Fire Marshal Division

November 8, 2018

Re: Tree of Knowledge Daycare

Application Numbers – BCOM1809-0002

1 FIRE ALARM PLAN
FA-1 Scale: 3/16"=1'-0"

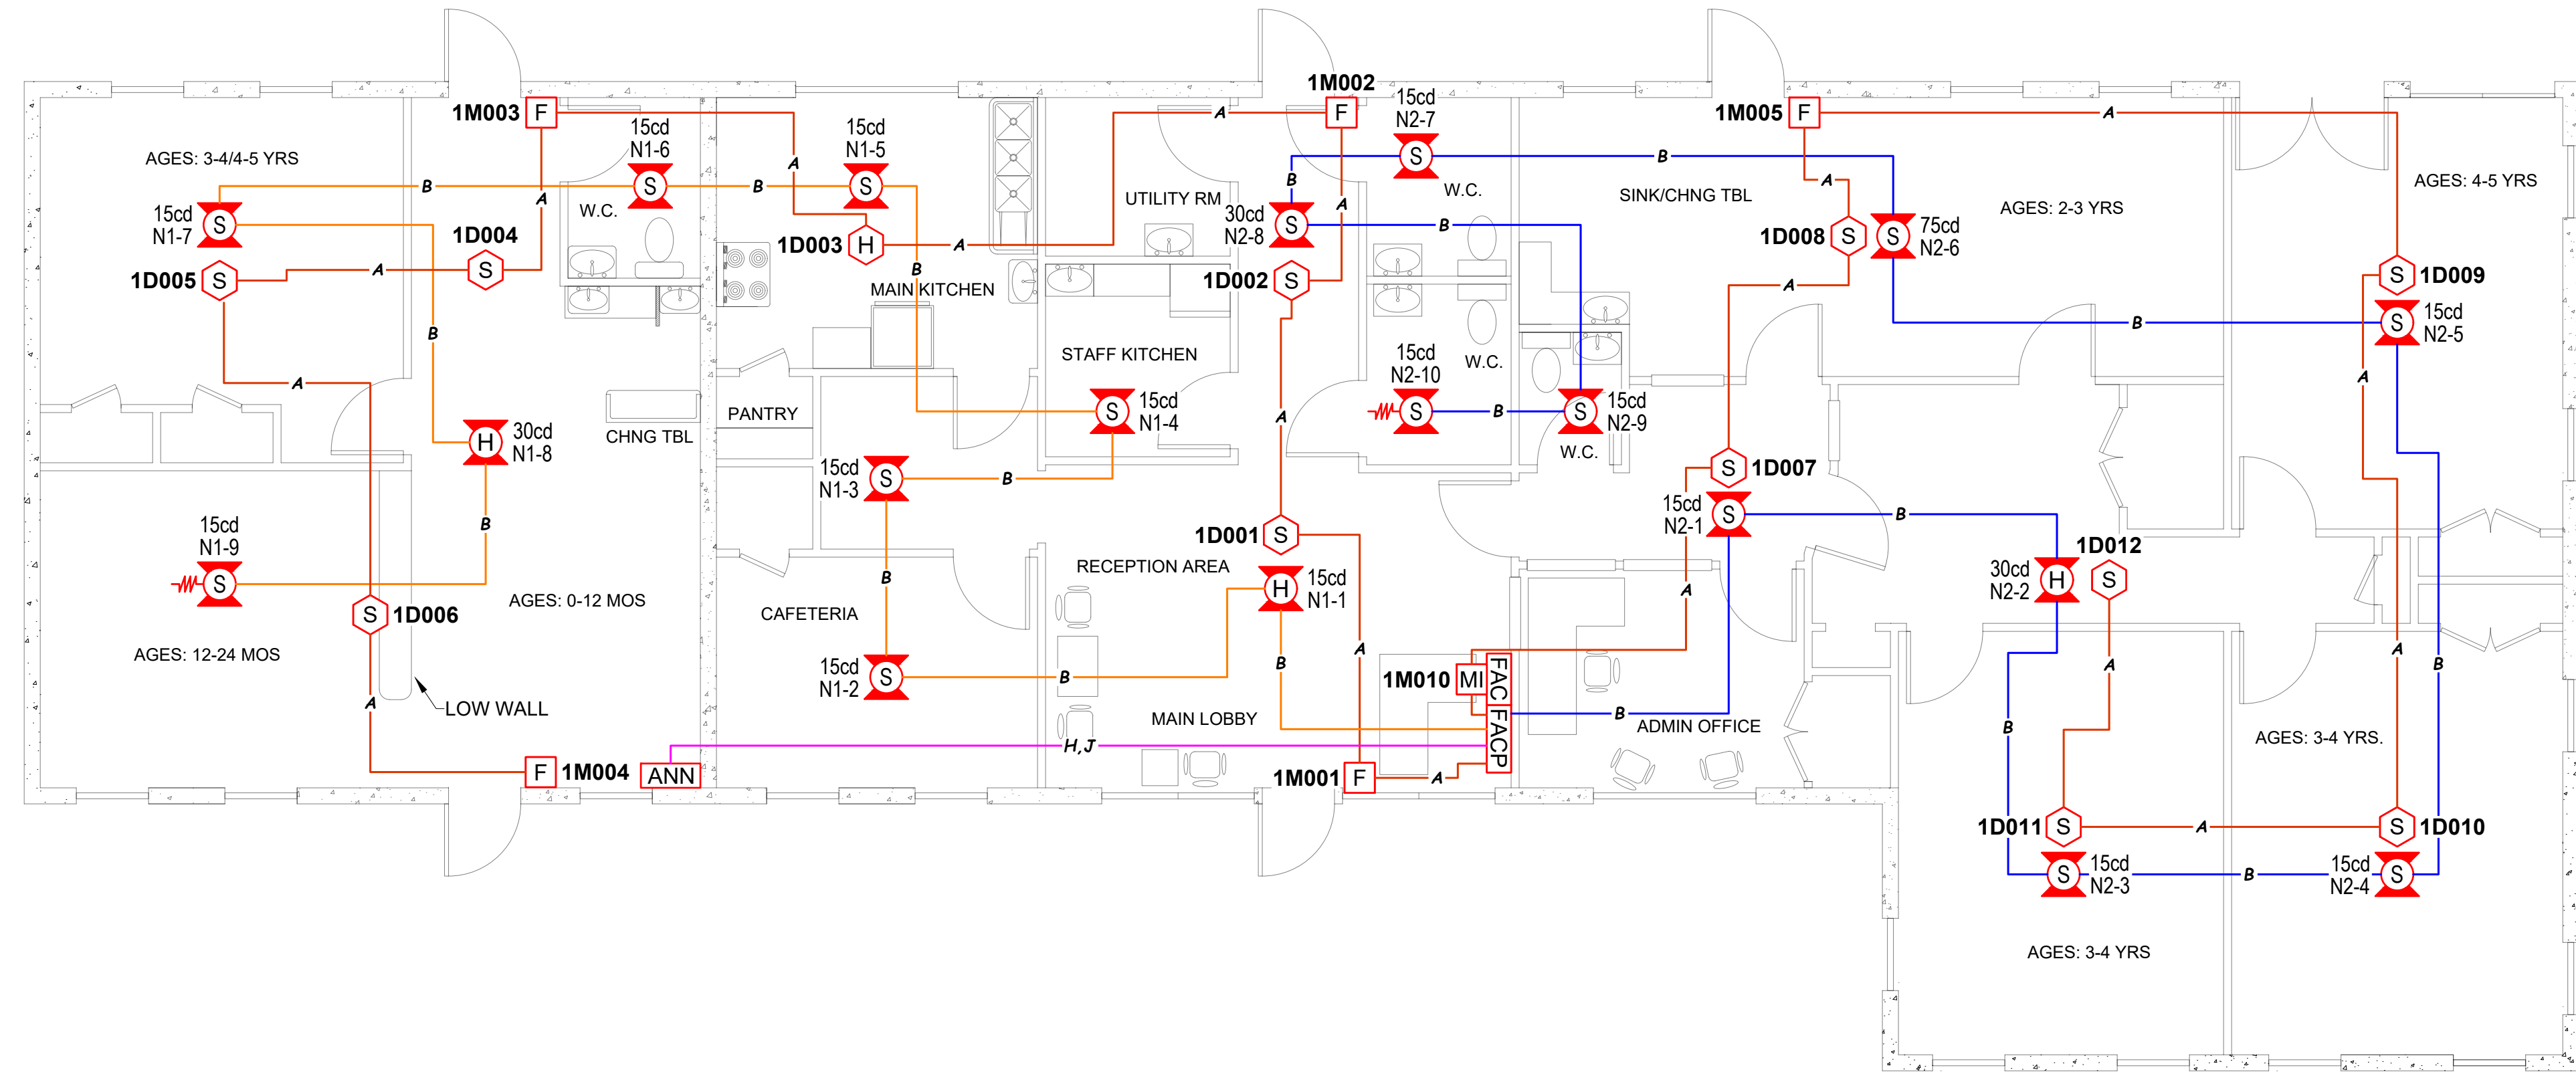
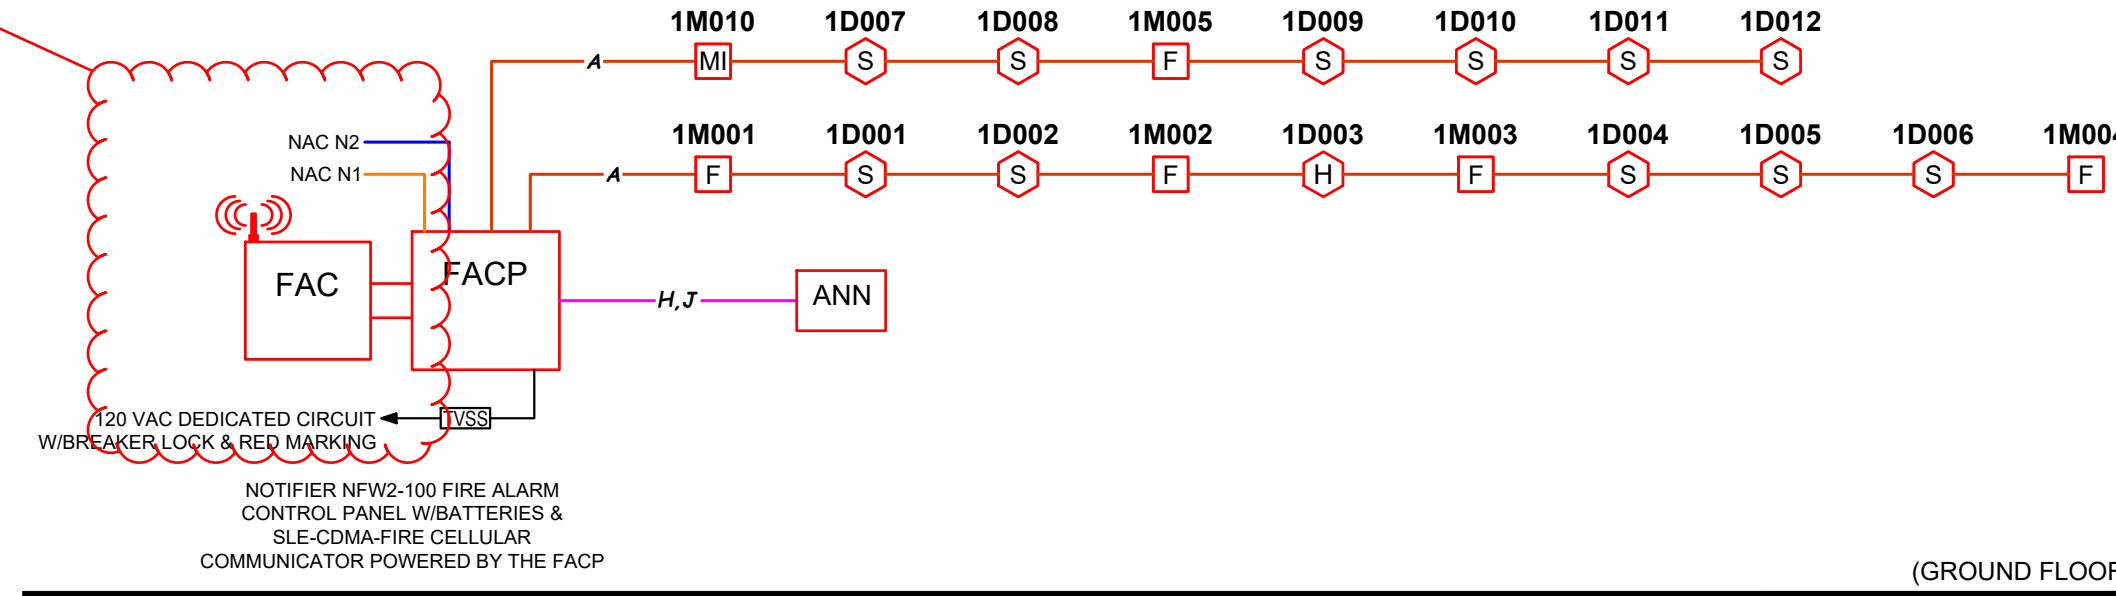
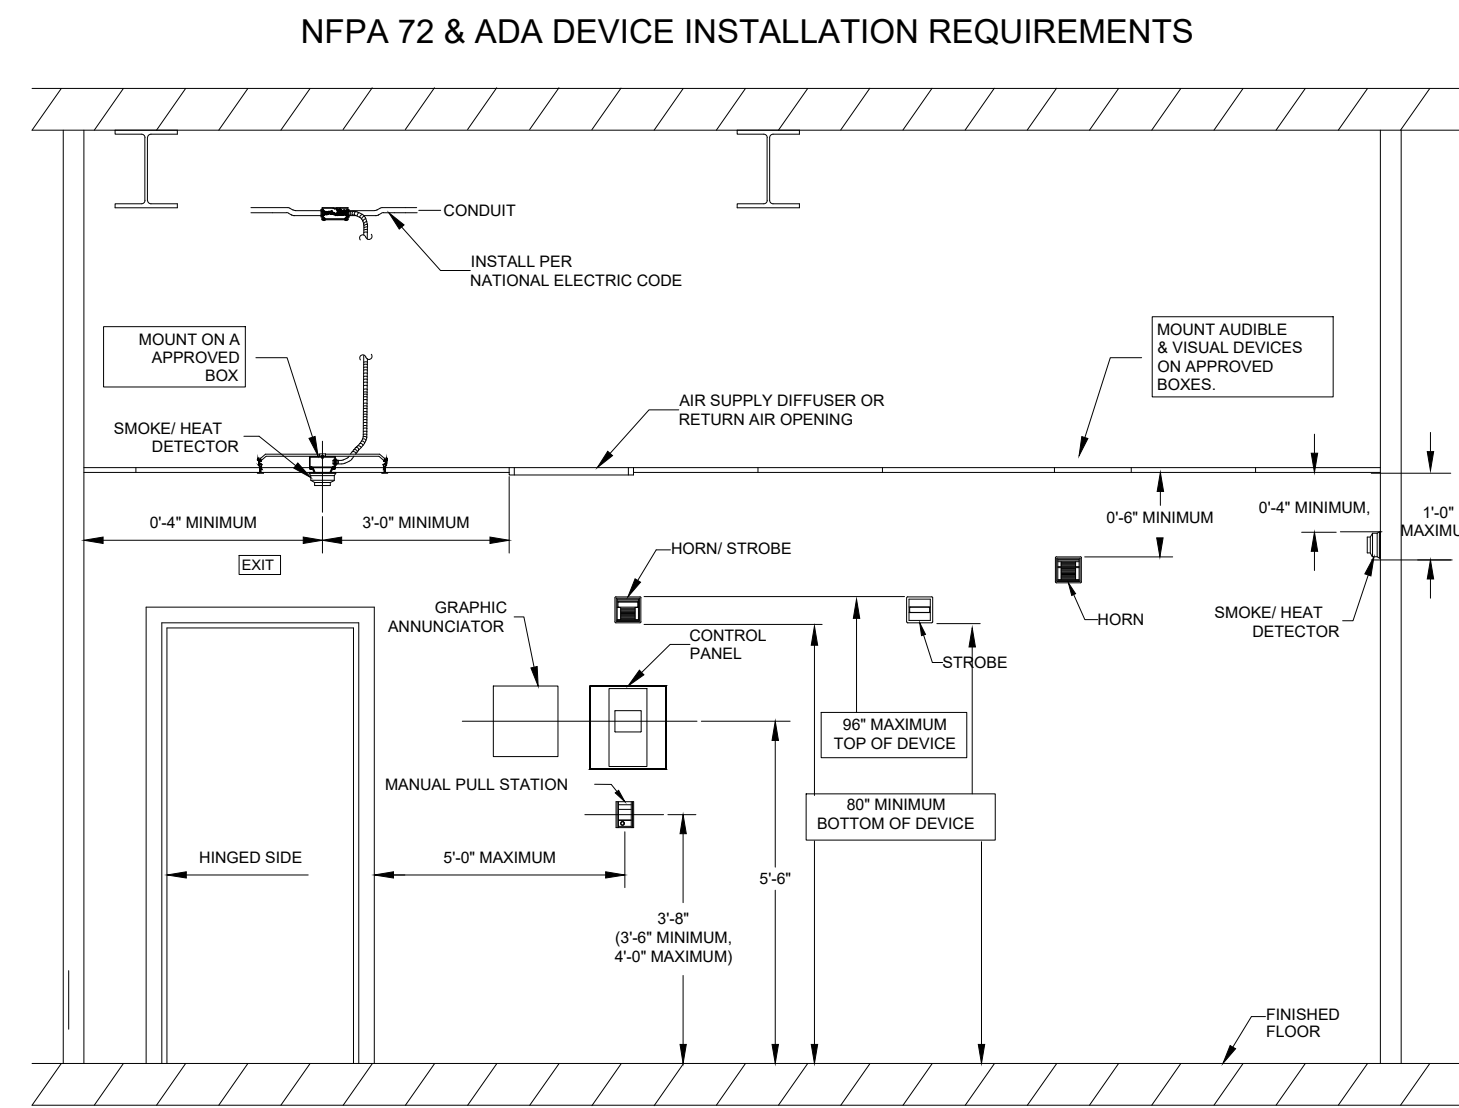
All items in notes are to be completed at the time of final.

- Provide a record of completion.
 - The Fire Marshal's office will complete an acceptance test at completion of project.
 - Provide a copy of account history after the acceptance test is completed and approve.
 - Provide an accurate zone map at the FACP and remote annunciator panel.
 - All work/installation shall be compliant with the NCSFC and NFPA 72.
 - Call Fire Marshal's office to schedule the fire alarm acceptance test. (910-984-4003)
-
- **Notes**
 - **A fire alarm construction permit is required.**
 - **Please schedule all inspections through the Fire Marshal's Office. 910-984-4003.**
